### EXISTING SYSTEM APPROVAL

Existing System Approval

Property Location/Address: 97 SETTER CT ANGIER, NC 27501

Proposed Property Improvement: Proposed 24x35 Deck Using Cantilevers that will extend 3' closest to septic drain lines. (will be 5' from foundation)

PHYSICAL SURVEY

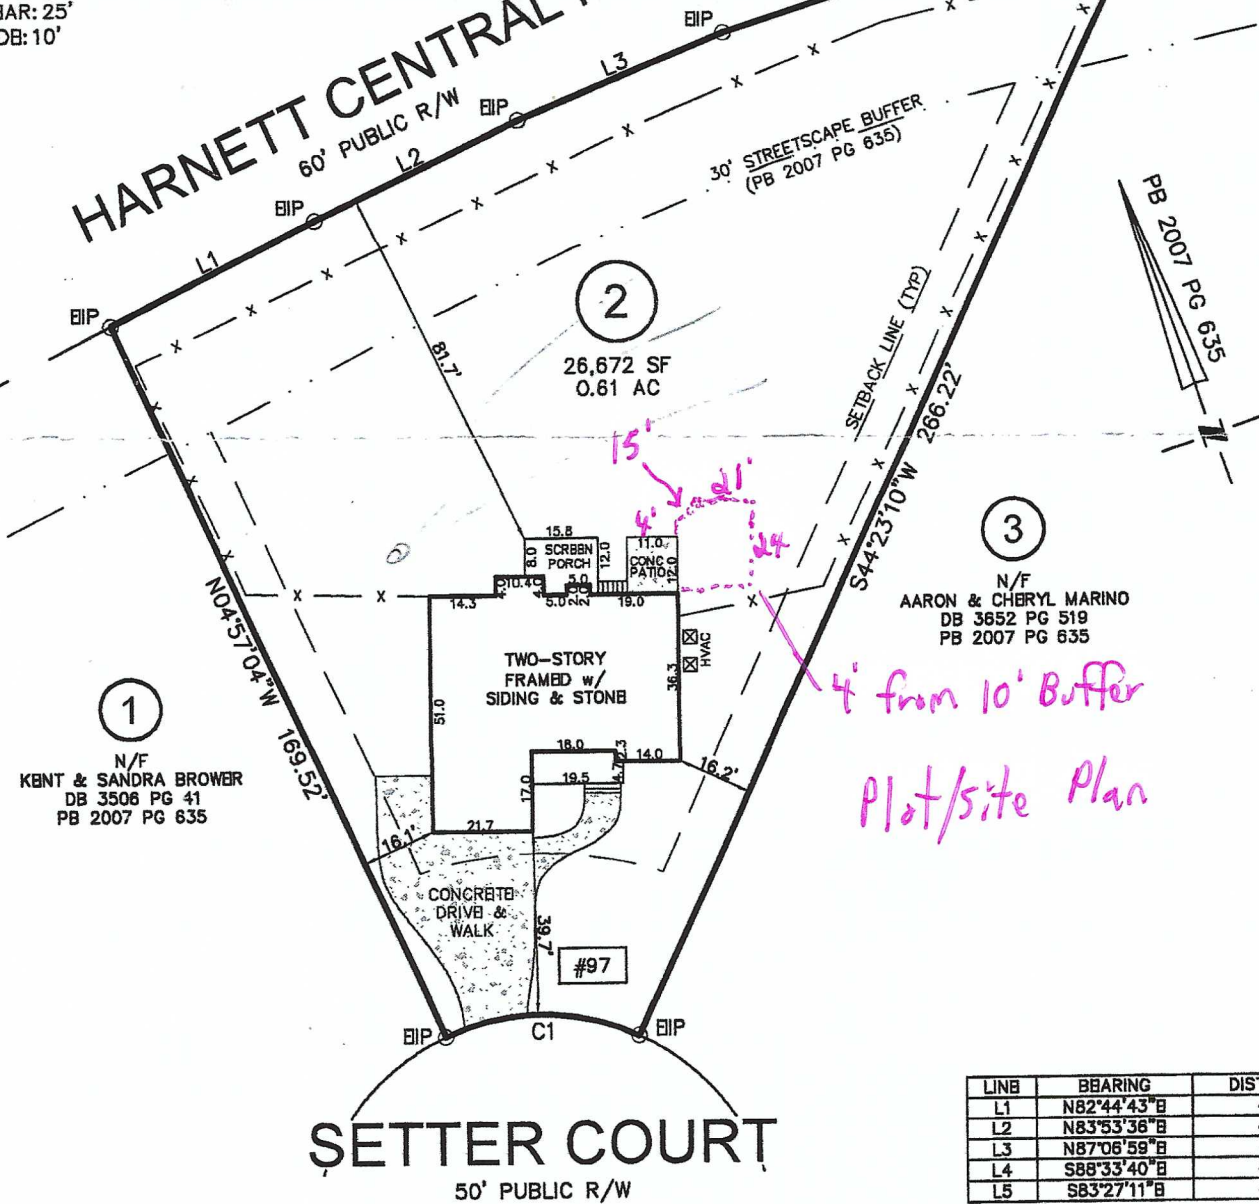
Approval Conditions: There is to be NO Driving over Septic Lines during Proposed Deck Installation.

New deck Plan
97 Setter court
Angier NC

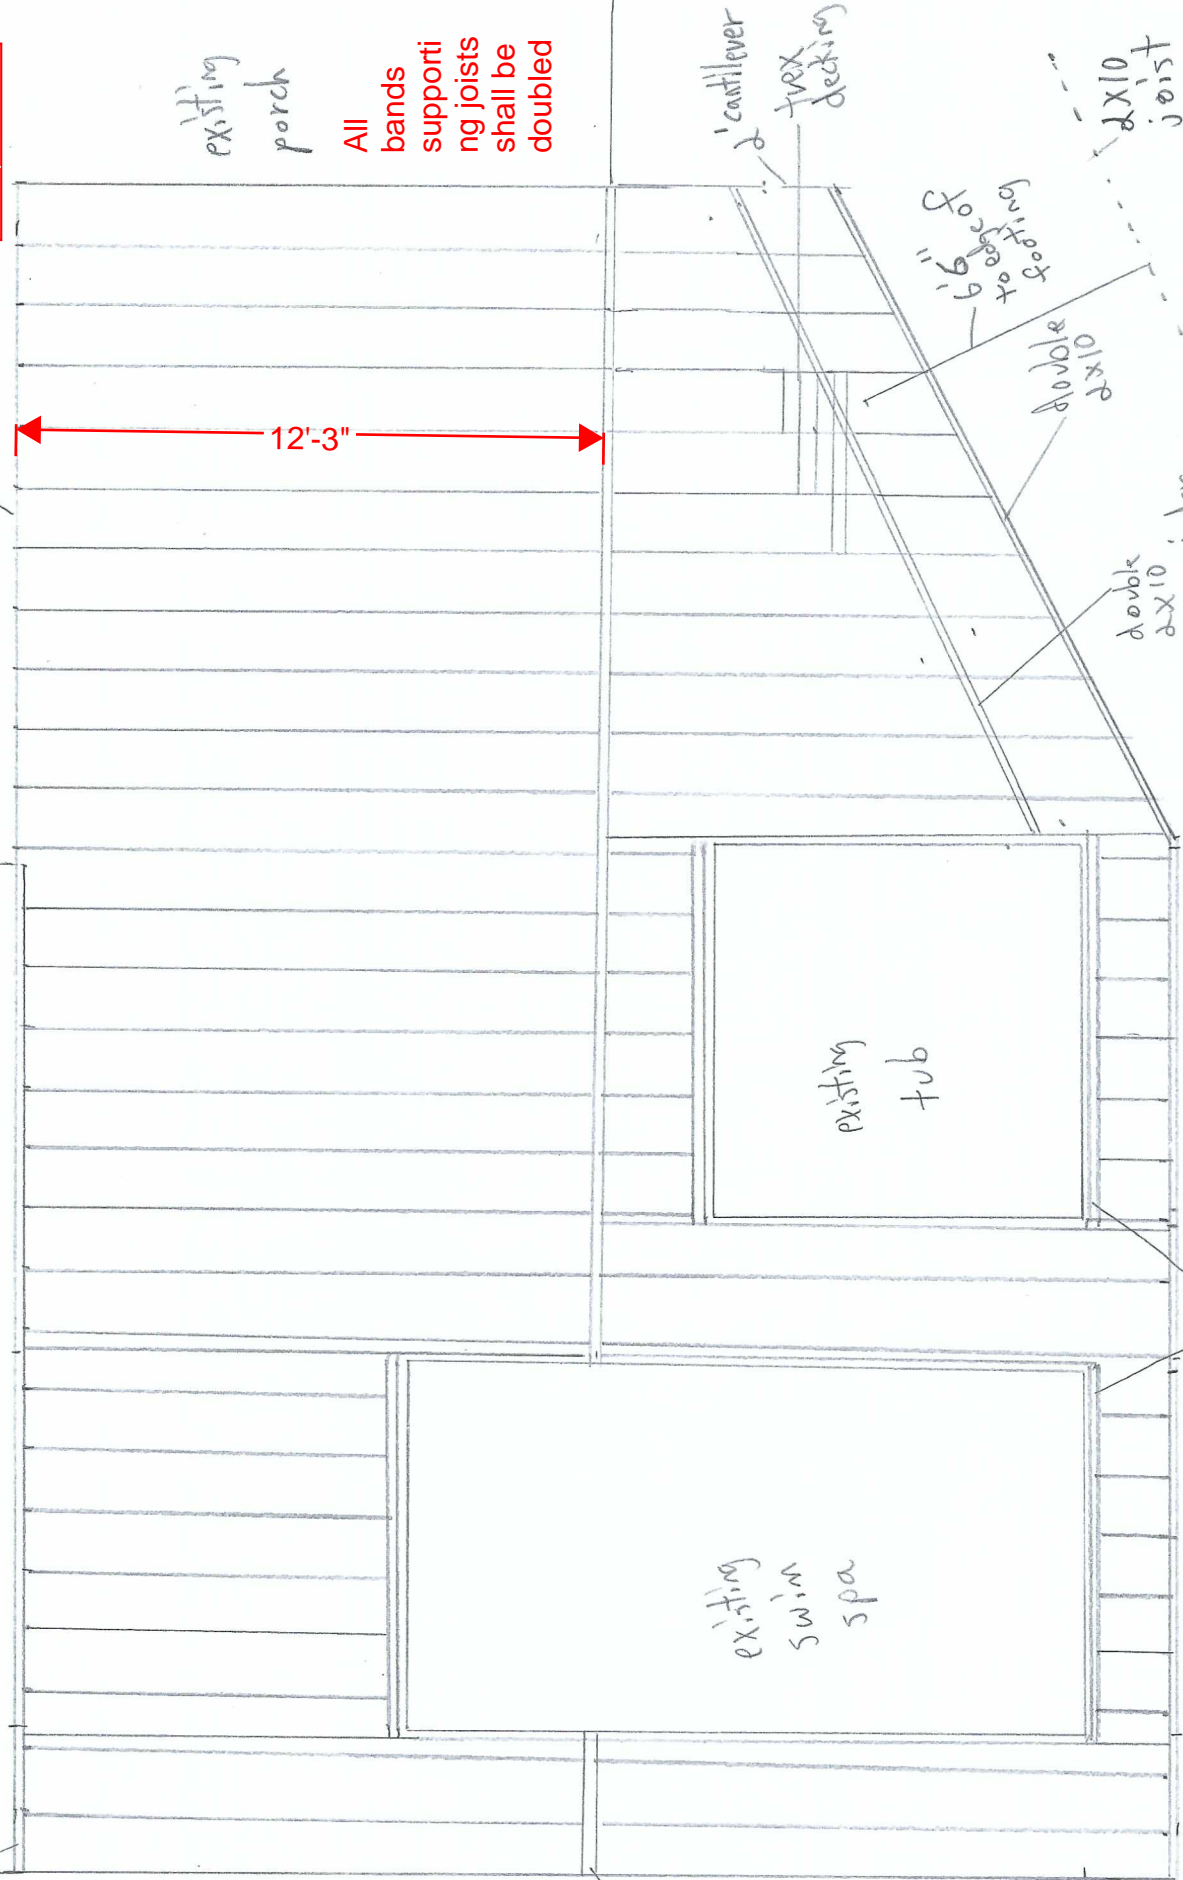
Cantilever must be used to meet 5' setback from deck. Must be a total of 5' from foundation post of the new proposed deck.
